Our Case Number: ABP-318704-23

Re: 10 year development of 9 Wind Turbines and associated infrastructure
at Borrisbeg and adjacent townlands, near Templemore town in Co. Tipperary
(<https://borrisbegplanning.com>)

Re: Section 37E of the Planning and Development Act, as amended – Planning Application to An Bord Pleanála for a Proposed Renewable Energy Development at Borrisbeg and adjacent townlands, Co. Tipperary

PROJECT TITLE: Borrisbeg Renewable Energy Development			
DRAWING TITLE: Wind Turbine Elevations & Plan			
PROJECT No.: 220310	DRAWING No.: 220310 - 21	SCALE: 1:500 @ A1	
DRAWN BY: GO	CHECKED BY: KD	DATE: 16.11.2023	REVISION.: P01

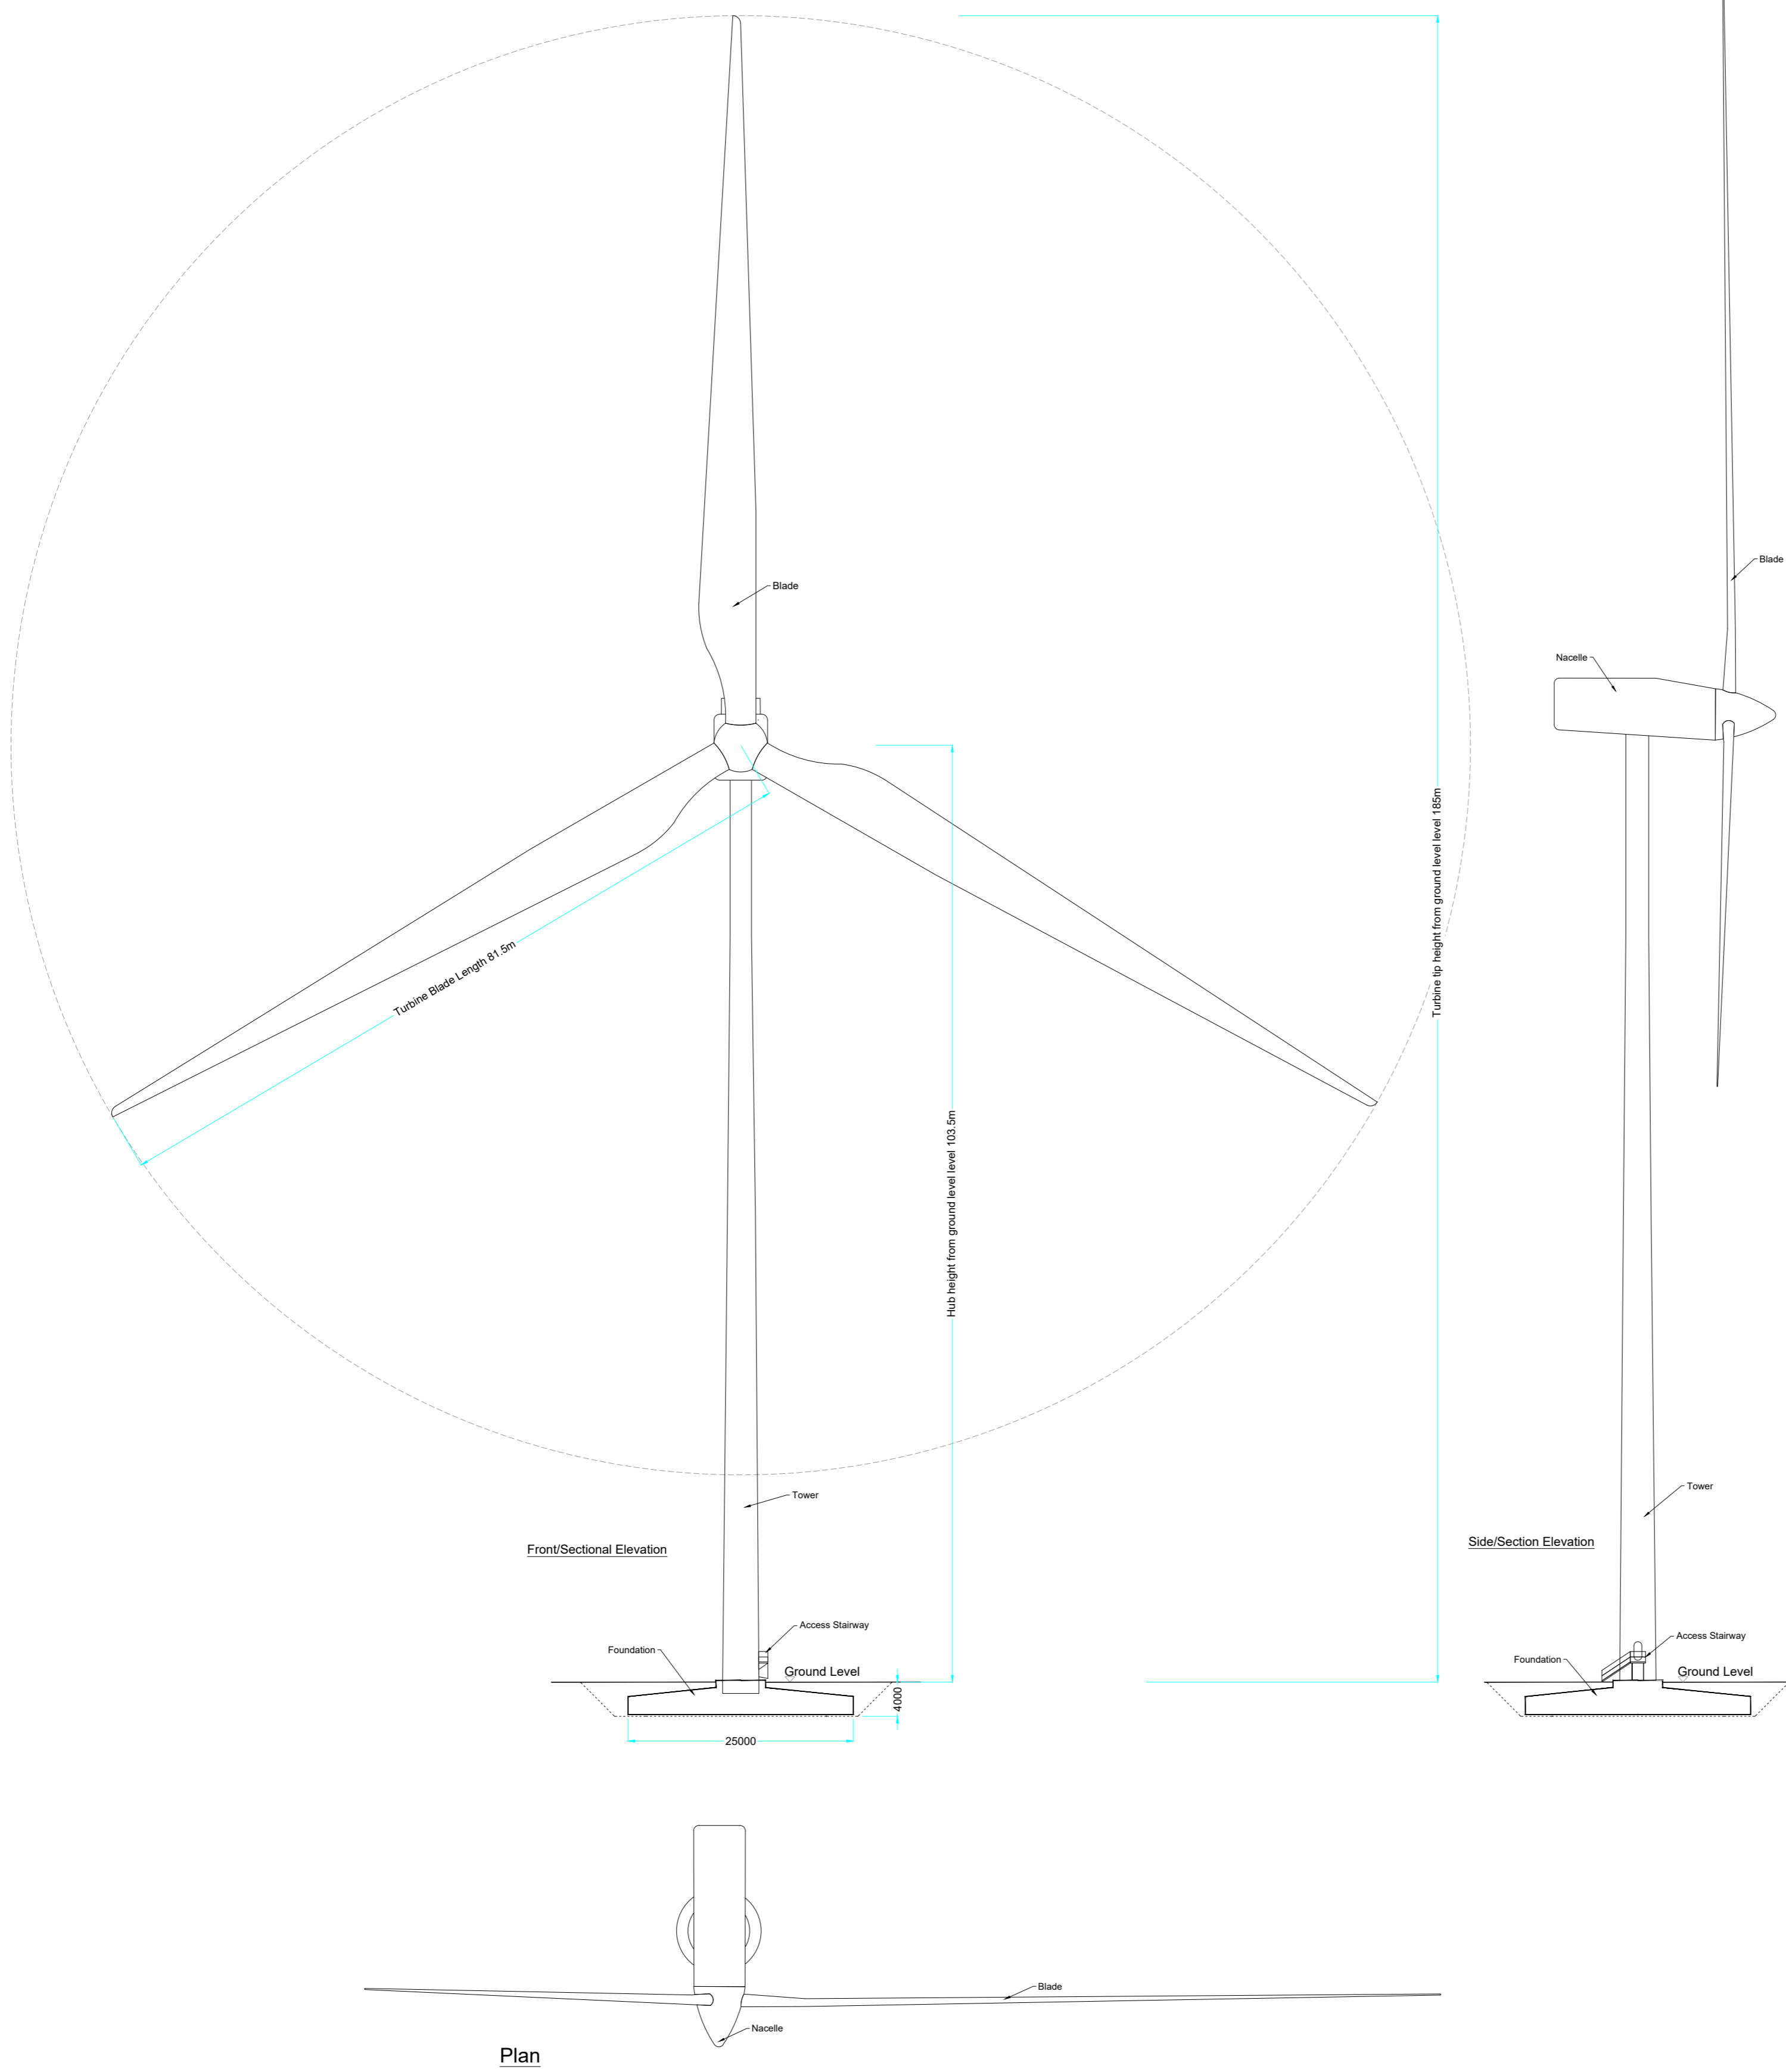
LCC notes that the principal dimensions of the proposed wind turbines are as follows:

- Maximum Tip height of 185m
- Hub height of 103.5m
- Maximum Rotor Diameter of 163m

LCC notes that a ratio in the order of 1:1 gives rise to the typical tall, slender and proportional appearance of the machines. However, LCC notes that when the rotor diameter exceeds by a significant margin the hub height, the entire structure may become dominant in views.

Therefore, An Bord Pleanála should be satisfied that when considered against the other reasonable alternatives considered in Chapter 3 of the EIAR, a potential ratio of tip height to hub height that is more than 1:1 (as in the proposed development) is acceptable.
